Application no: H23-0629-09

Description: Proposed new roof to accommodate rooms within, demolish attached garage, erect two-storey extension and replace existing single-storey flat roof with pitched roof to accommodate room within

ACKNOWLEDGEMENT OF AMENDMENT

**Re: Proposed new roof to accommodate rooms within, demolish attached garage new two storey extension and replace existing single storey flat roof with pitched to accommodate room within at 'The Ridings' Shepeau Stow, Whaplode Drove, Spalding, Lincs. PE12 0TU for Mr. & Mrs I. Jibb
Planning Reference Number : H23-0629-09**

Proposed Rear Elevation

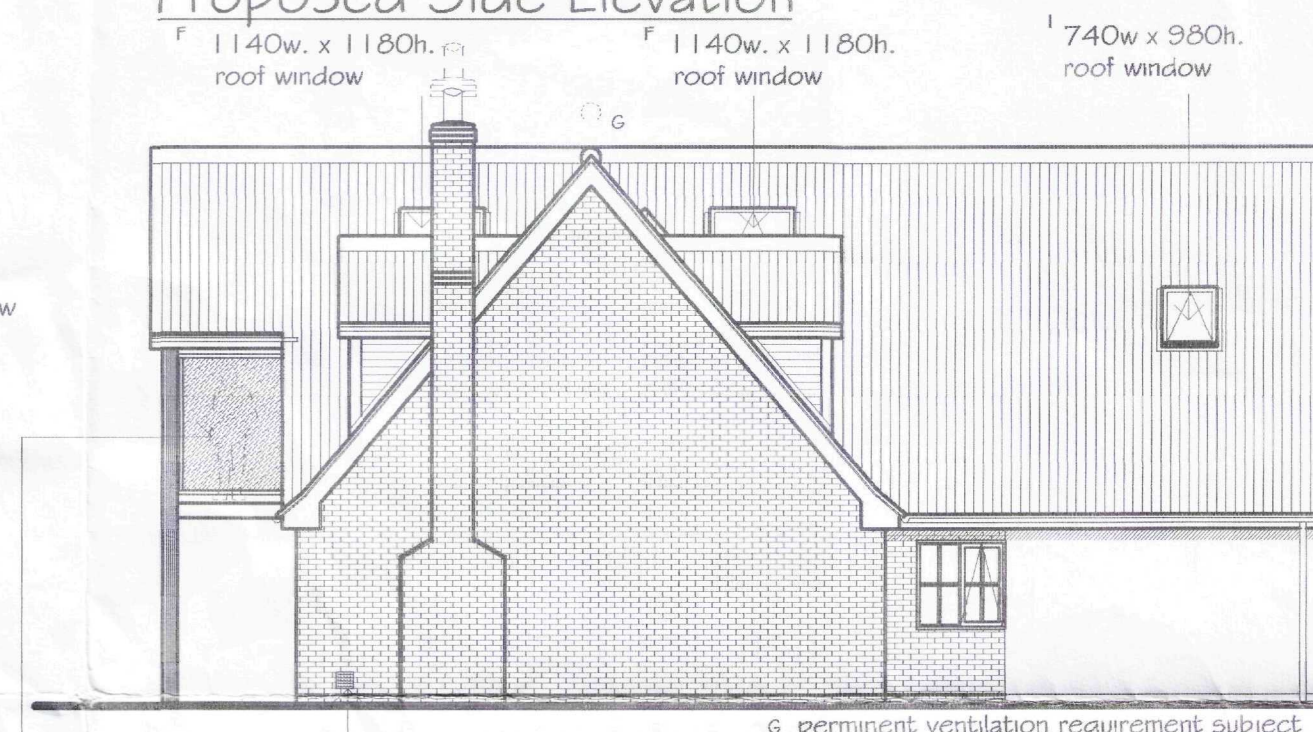
Following our meeting yesterday at the above offices please see attached single copy of revised drawing 255/2/2008J incorporating revisions discussed i.e. additional opaque full height glazing to the remaining side elevation of the rear balcony. I have also shown on all sections an 1800 high person next to all roof windows to confirm there cannot be any overlooking to neighbouring properties. I would also like to confirm that two of the three dormers to the rear elevation have opaque glazing.
